**Addendum No. 1**

RE: Contract ID C203631  
WBS # 3CR.10671.169 Etc.  
State Funded

NC-111 From Duplin County Line To SR-1221, NC-172 From US-17 To Pvmnt.  
Change Before NC-210 & 13 Sections Of Secondary Roads

**January 20, 2015 Letting**

PROJECT NO.	SHEET NO.	TOTAL NO.
3CR.10671.169, ETC.	15

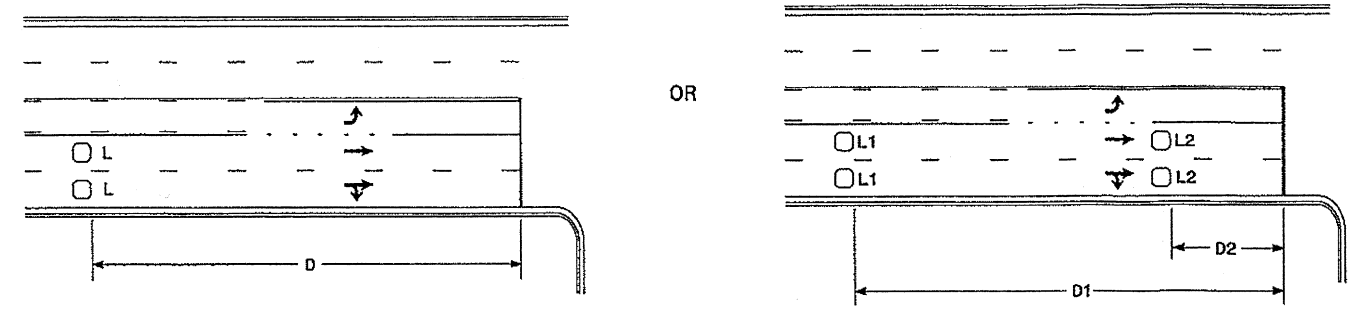
On Sheet No. 15 the quantity of "Pavement Interlayer" has been revised. Please void Sheet No. 15 in your plans and staple the revised Sheet No. 15 thereto.

<u>Item</u>	<u>Description</u>	<u>Old Quantity</u>	<u>New Quantity</u>
021-1891000000-E- SP	Pavement Interlayer	40,716 SY	62,568 SY
